ROADWAY PLANS WYOMING ESTATES SUBDIVISION EL PASO COUNTY, CO

PCD PROJECT NO. MS196

ROADWAY COVER

ROADWAY PLAN,
PROFILE, DETAIL AND
SECTION

| SHEET 1  |                           |  |            |       |  |          |

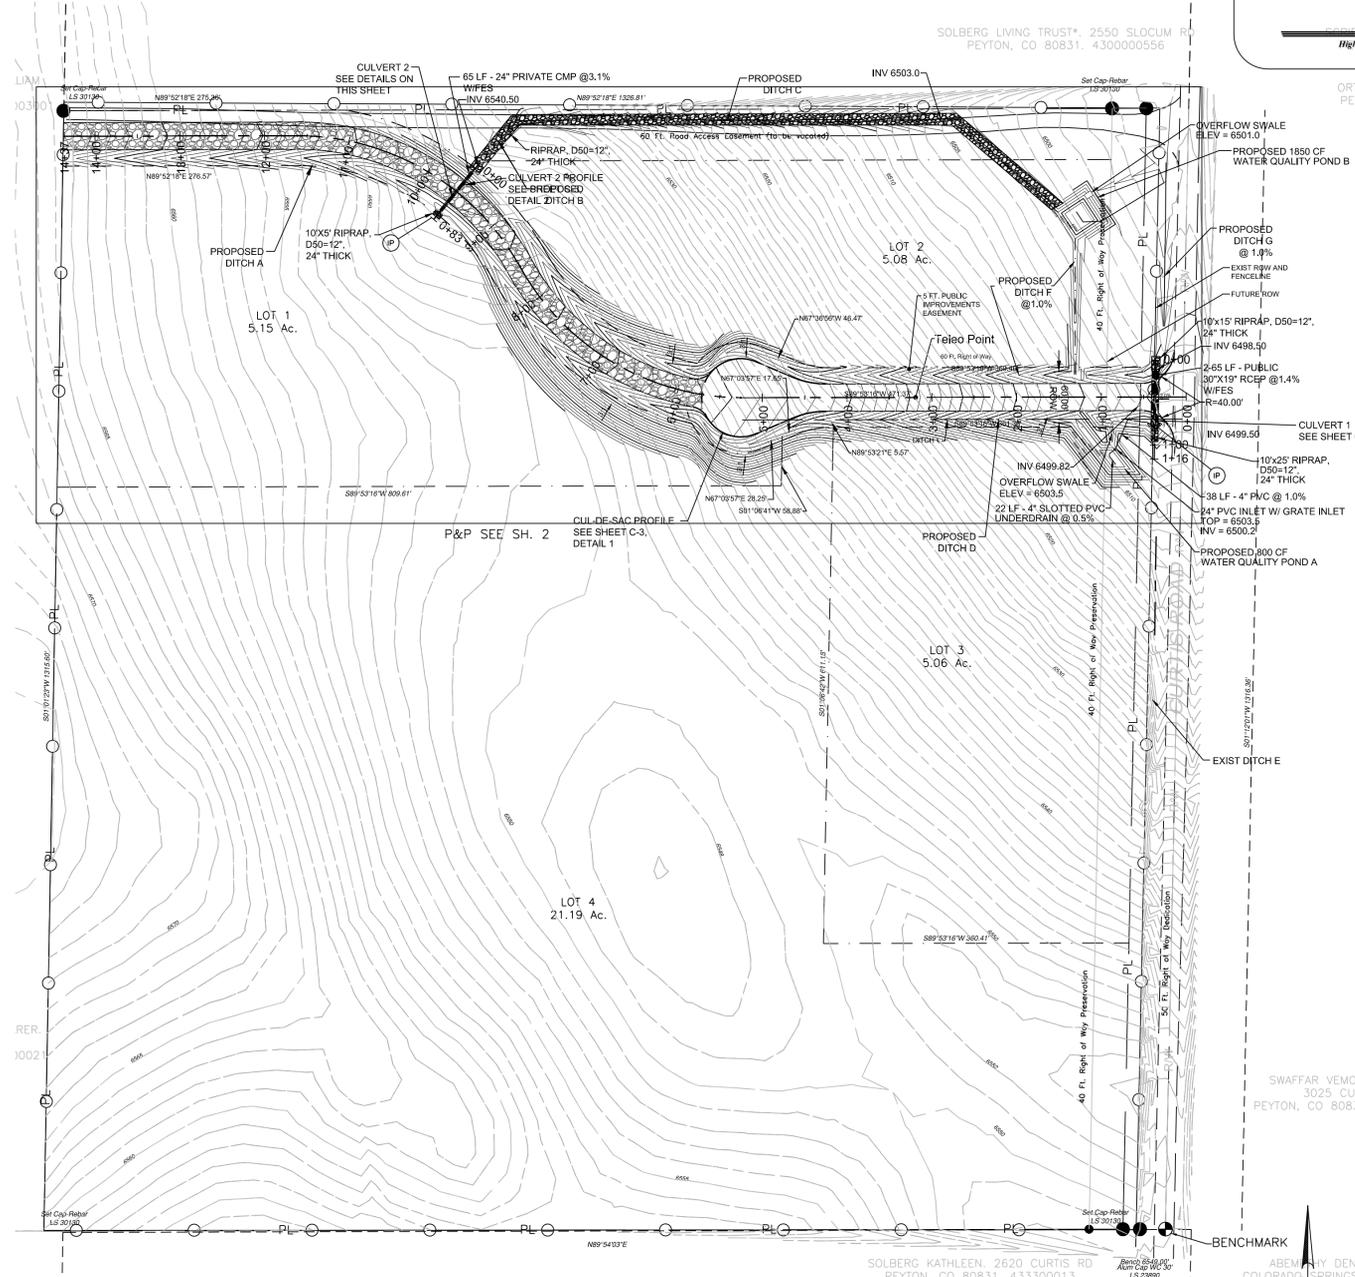
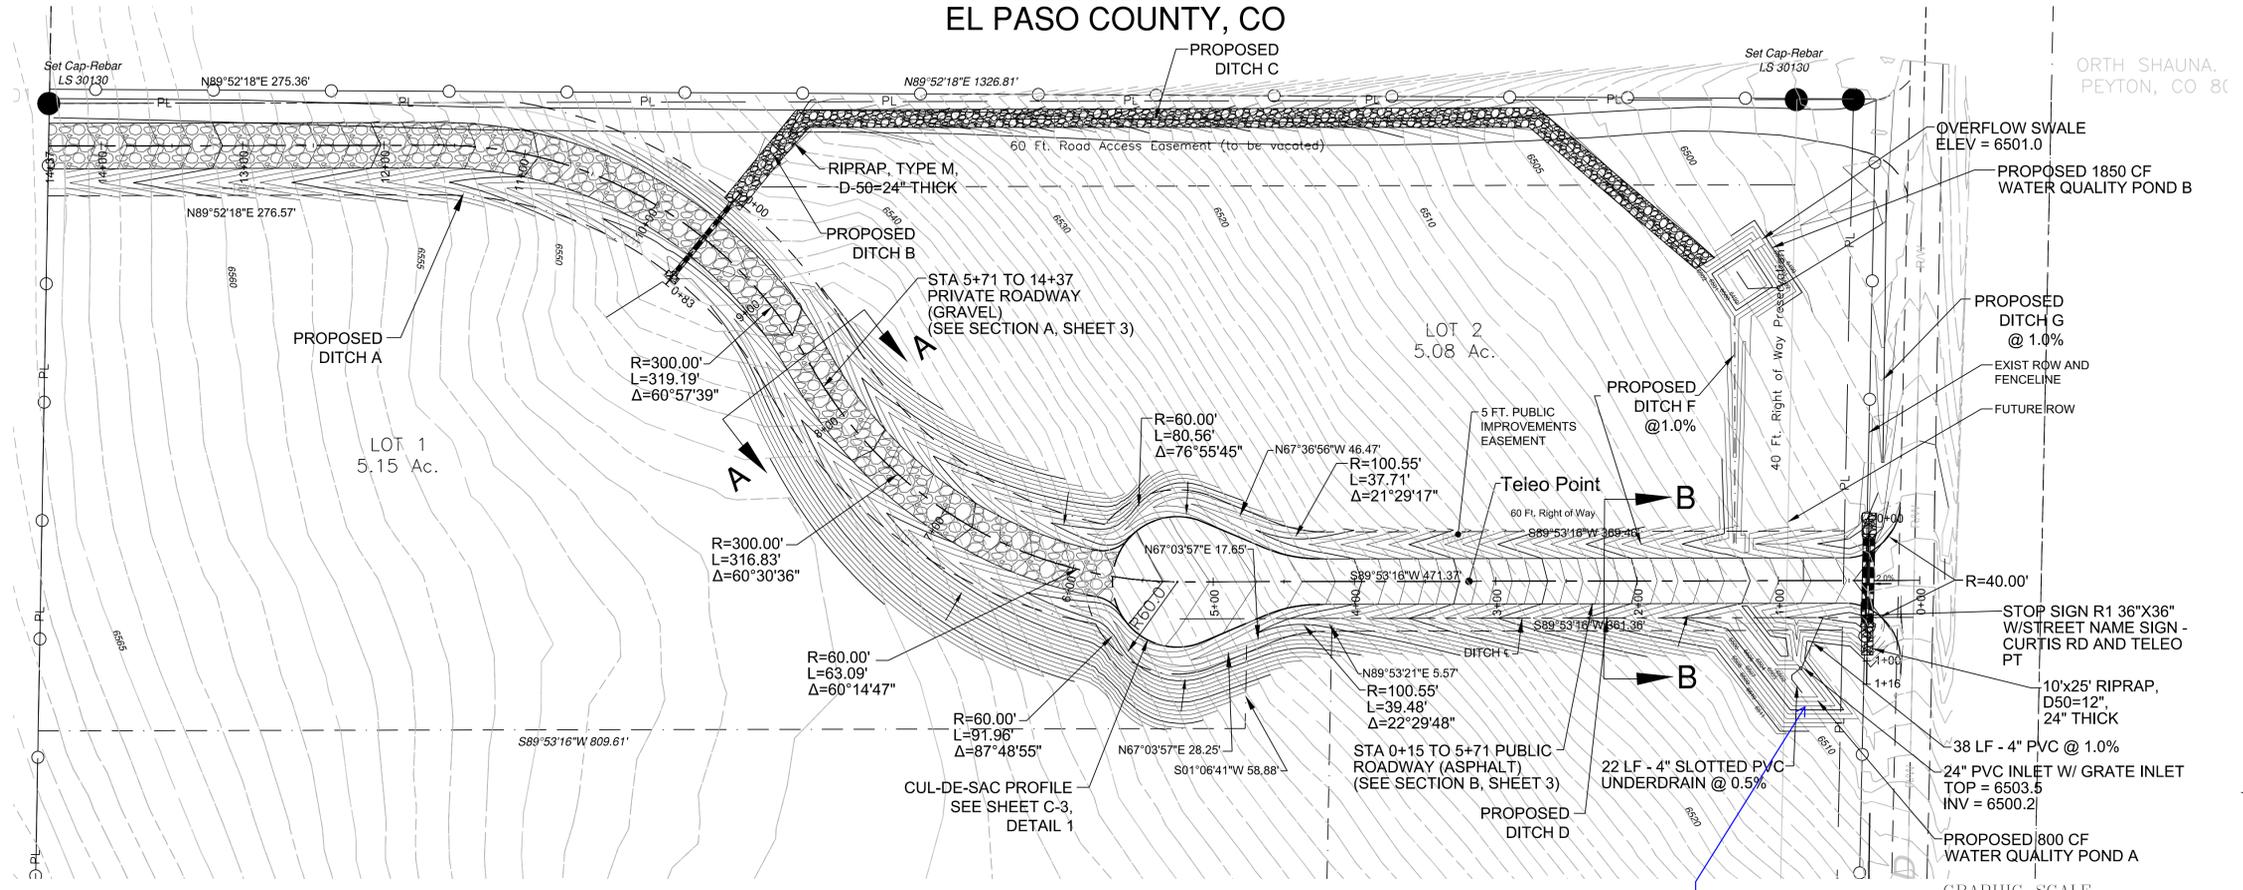
Review 1 comment: Please use the standard EPC signature block. These detailed plans and specifications were prepared under my direction and supervision. Said plans and specifications have been prepared according to the criteria established by the County for detailed roadway, drainage, grading and erosion control plans and specifications, and said plans and specifications are in conformity with applicable master drainage plans and master transportation plans. Said plans and specifications meet the purposes for which the particular roadway and drainage facilities are designed and are correct to the best of my knowledge and belief. I accept responsibility for any liability caused by any negligent acts, errors or omissions on my part in preparation of these detailed plans and specifications.
Review 2: Unresolved

Revise development services department (DSD) to "Planning and Community Development Department (PCD)"

Review 1 comment: Please use the standard EPC signature block. I, the owner/developer have read and will comply with the requirements of the grading and erosion control plan and all of the requirements specified in these detailed plans and specifications.
Review 2: Unresolved

# ROADWAY PLANS WYOMING ESTATES SUBDIVISION EL PASO COUNTY, CO

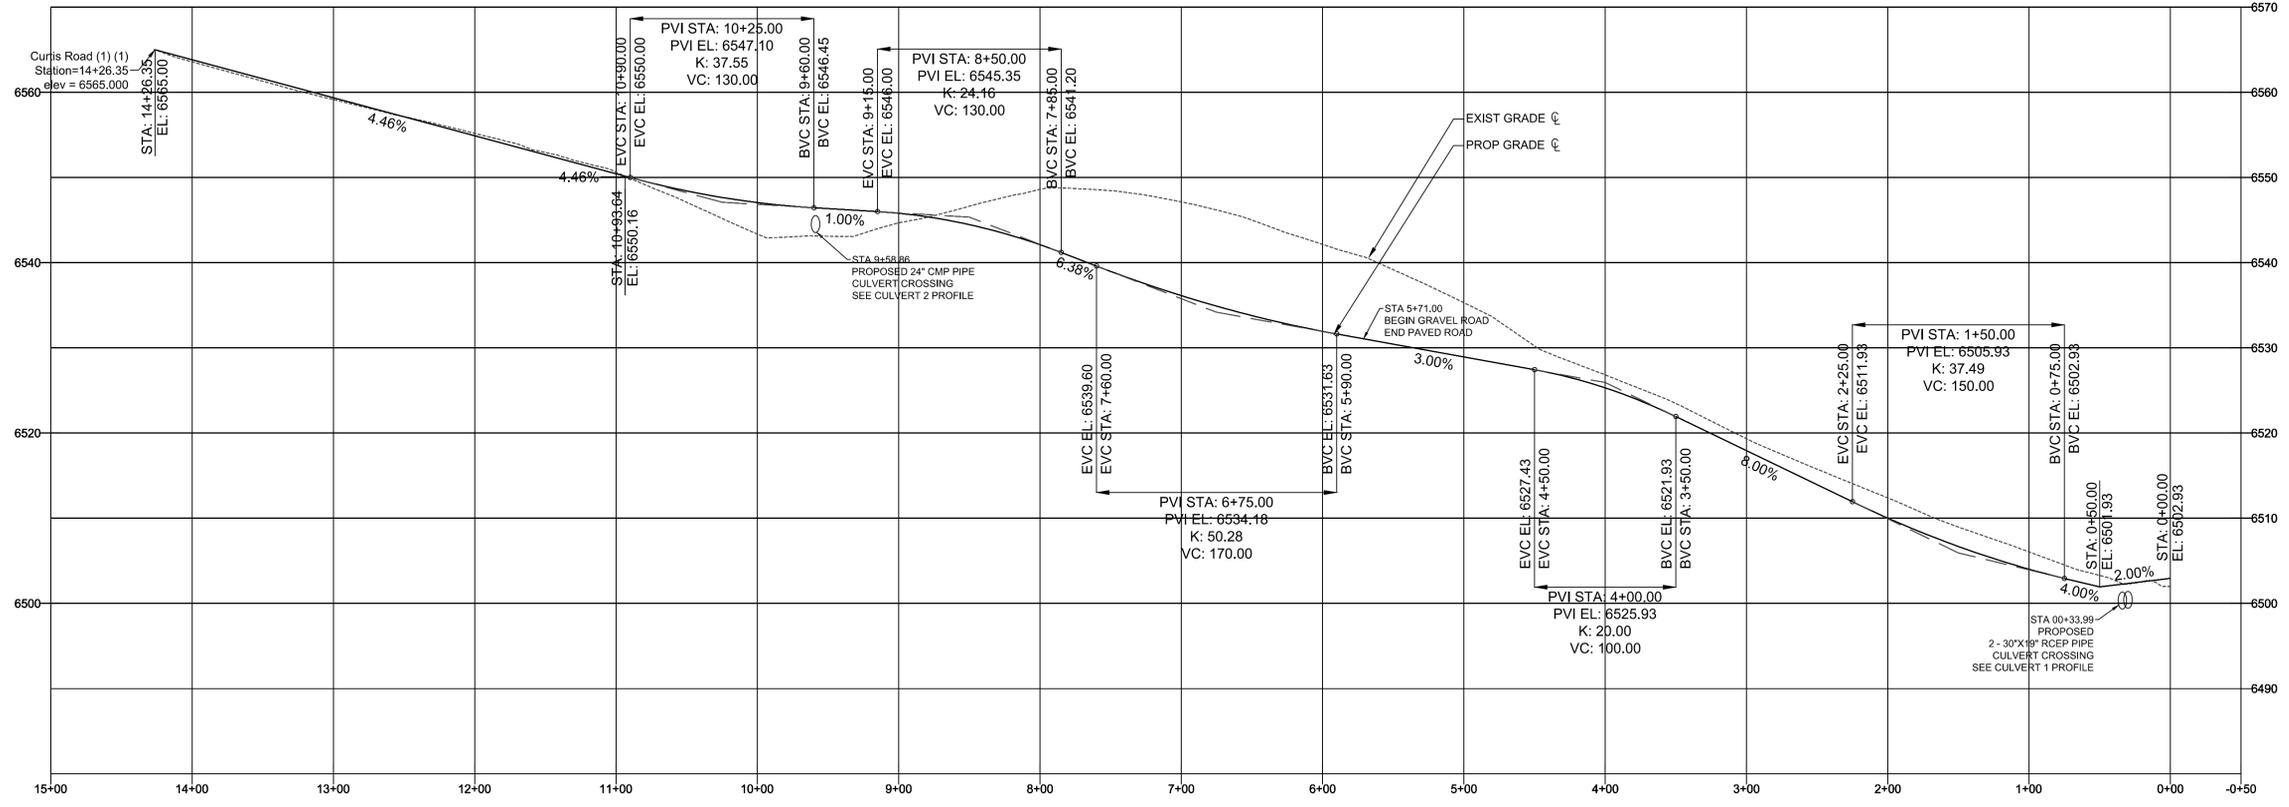
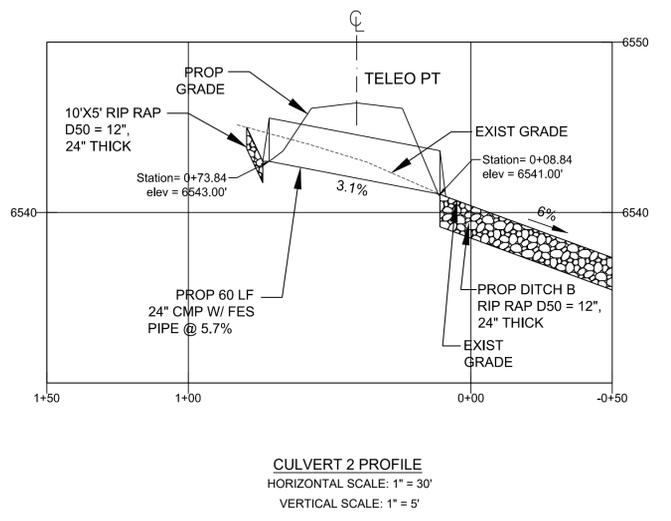
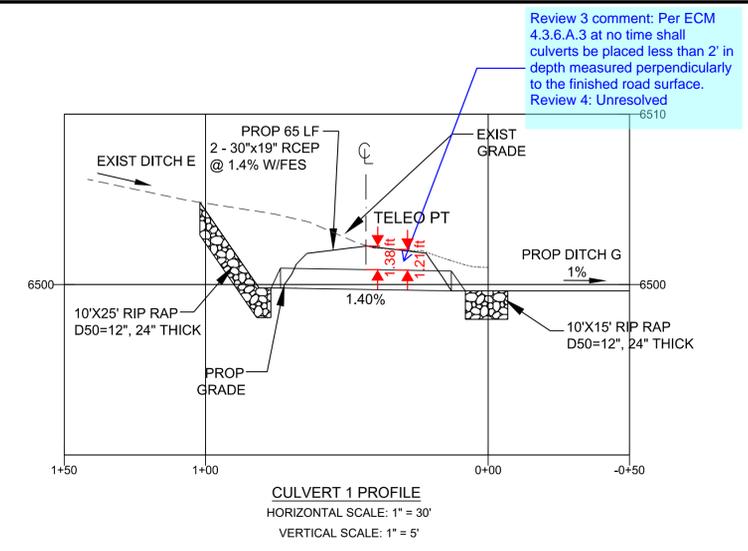
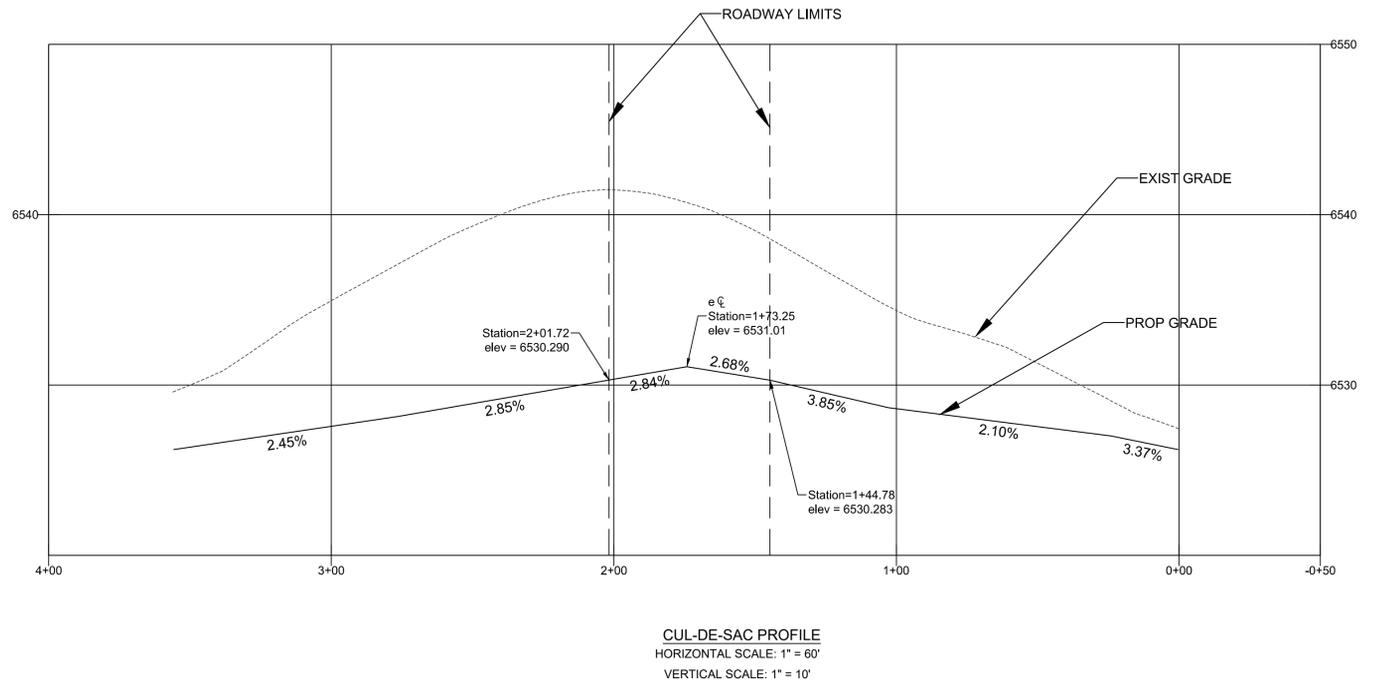
Review 1 comment: Provide a cross section of the proposed gravel access road.
Review 2: Unresolved

Review 1: Per ECM table 2-32 the min. radius at minor arterials is 40'. Please revise.
Review 2: Unresolved

Please show the slope per the standard County detail as well as the point of slope selection (hinge point)

Please label the 5' public improvements easement.
